Application for removal or variation of a condition following grant of  
planning permission. Town and Country Planning Act 1990.  
Planning (Listed Buildings and Conservation Areas) Act 1990

The demolition of the existing building and erection of a part 4 and 5 storey building with additional part lower ground floor comprising two 1 bedroom, three 2 bedroom two 3 bedroom flats and provision of commercial retail unit at ground floor. Provision of external amenity space.

DC/19/03203/FULL1

2 - Carried out in accordance with approved drawings  
9 - Formation of a car club

Project No.	Date
<b>7451</b>	MAY 2021
Drawing No.	Revision
<b>7451-PD-205</b>	
Scale	Drawn
1:100 @ A1	MN
	Check
	RC

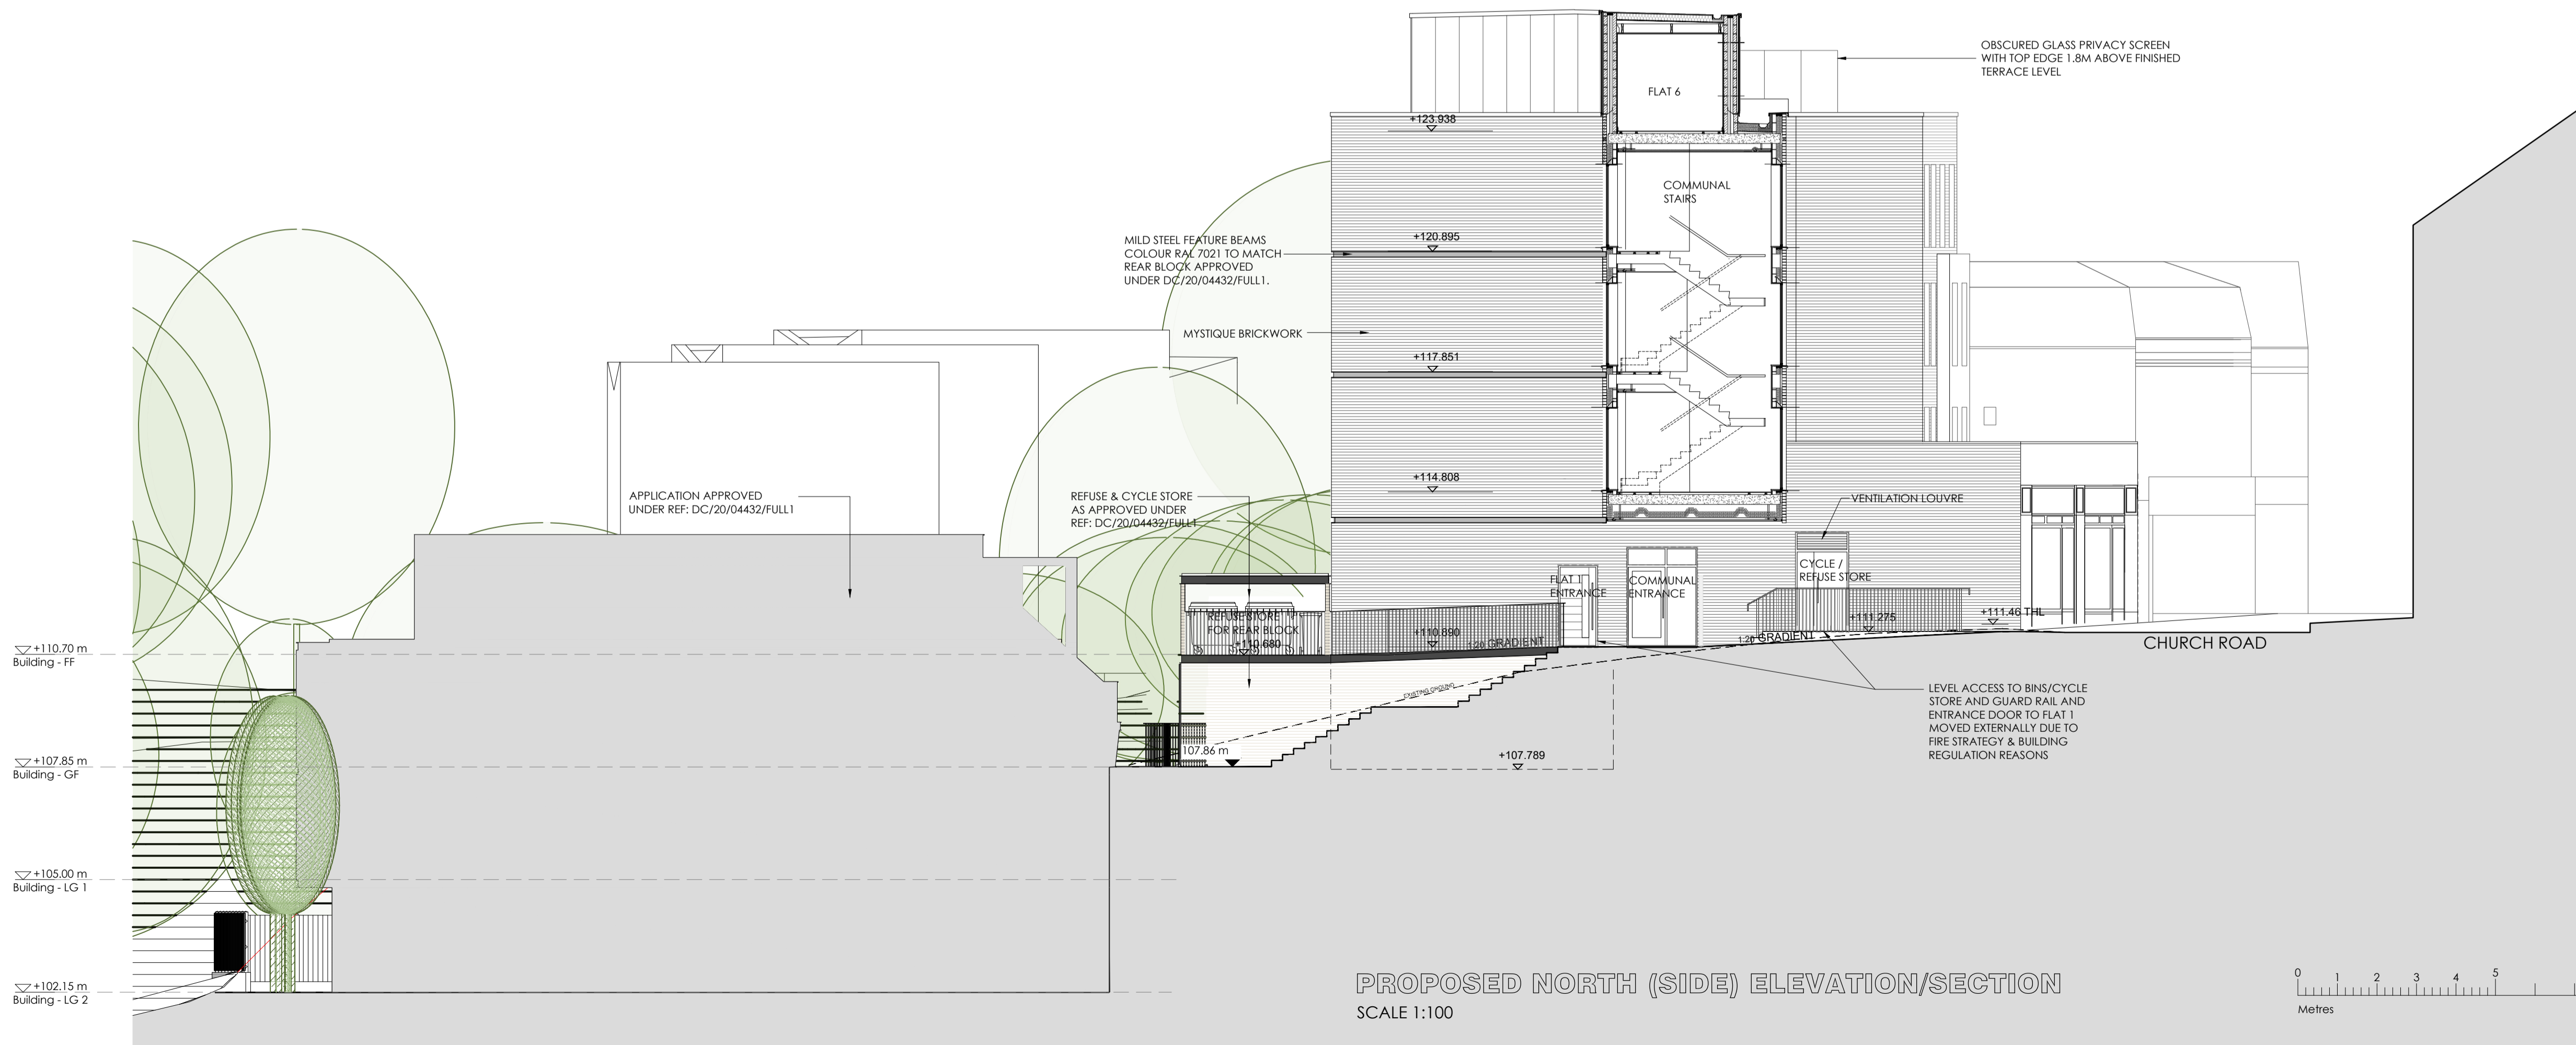
Due to Building Regulation requirements the footprint has increased slightly to accommodate compliant layouts in terms of fire strategy and London Design Guide. Window and door positions to the side and rear have also been revised to suit the new layouts.

Drawing G686\_1101\_C to be superseded with 7451-PD-200  
Drawing G686\_1102\_B to be superseded with 7451-PD-201  
Drawing G686\_1103\_B to be superseded with 7451-PD-202  
Drawing G686\_1106\_A to be superseded with 7451-PD-203  
Drawing G686\_1107\_A to be superseded with 7451-PD-204  
Drawing G686\_1108\_A to be superseded with 7451-PD-205
